## **Development Facilitation Team (DFT) – Review Comments**

**DRB Project No: PR-2023-008250 Date: 03/01/2023 Agenda Item: #2 Zone Atlas Page: B-15**

**REQUEST:** SITE PLAN ADMIN – DFT: Glass-Rite New Office/Warehouse: 5605 Venice Ave. NE

**Project Name:** Glass-Rite New Office/Warehouse: 5605 Venice Ave. NE

1 SITE PLAN
1"=20'-0"

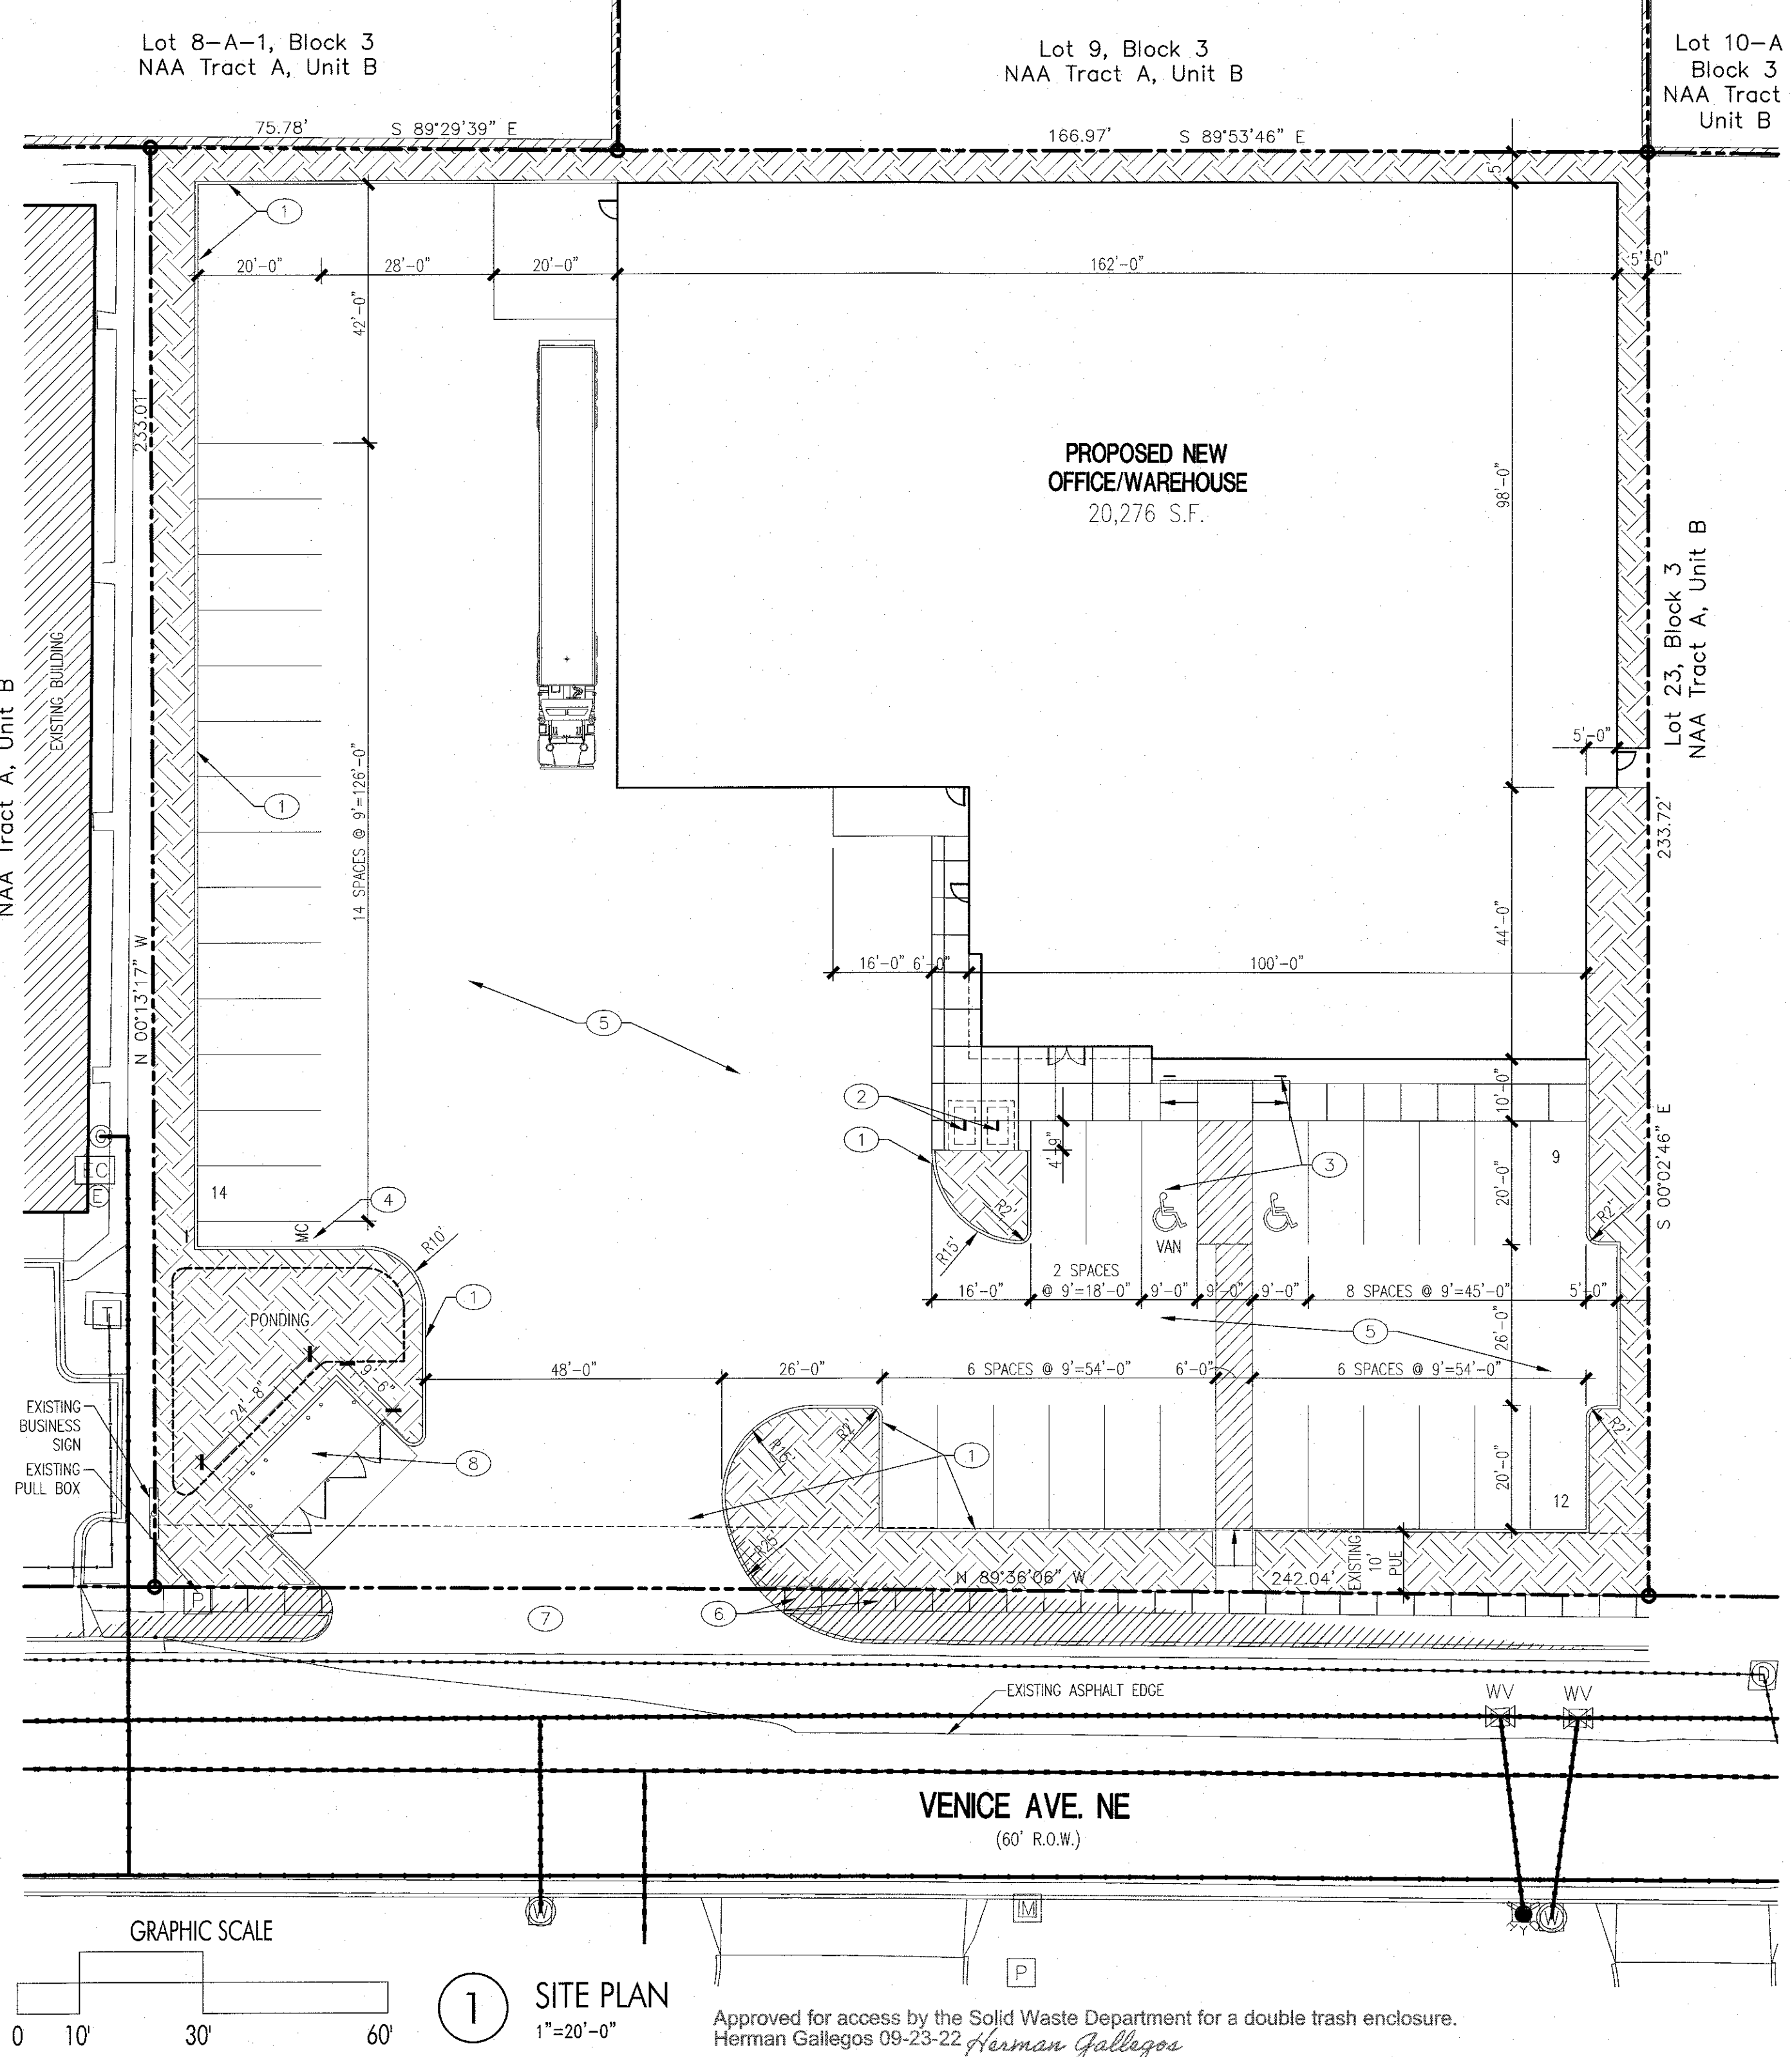
1. Property is zoned NR-LM (incorrectly noted at NR-BP in submittal letter and on Site Plan). Must meet all Dimensional Standards for NR-LM, as per IDO 5-1(E), Table 5-1-3.

3. Property must meet all requirements of IDO 5-3 Access and Connectivity and 5-4 Subdivision of Land.
4. Site Plan indicates 24 parking spaces provided, but 35 spaces are shown on plan. This is more than sufficient, but the site plan should be corrected to accurately reflect actual spaces to be provided.

- The zoning of the site on the Site Plan is incorrectly labeled NR-BP. The correct zoning for the site is NR-LM.
- Due to an Infrastructure List with public infrastructure being included with this application submittal, this proposed development requires Site Plan Administrative DFT approval in addition to Building Permit(s) approval(s).
- A recorded Infrastructure Improvements Agreement (IIA) based on the Infrastructure List must be submitted prior to final sign-off of the Site Plan by DFT staff should the Site Plan be approved.
- The project (PR-2023-008250) and application (SI-2023-00376) numbers must be added to the Site Plan.
- All development must meet standards and provisions of the IDO (**NR-LM**) and the DPM.

- ❖ DPM Table 7.2.29 – Street Element Dimensions.
  - \* **As Venice Avenue NE is a local street and the site is located outside an Urban Center, a 5-foot wide sidewalk and a 5-6-foot-wide landscape/buffer zone is noted on Table 7.2.29 along the frontage of such a roadway. The Infrastructure List included with the application submittal depicts a 4-foot wide sidewalk along the north side of Venice Avenue NE.**

**Please provide confirmation if a 5-6-foot-wide landscape/buffer zone is proposed on the Site Plan.**
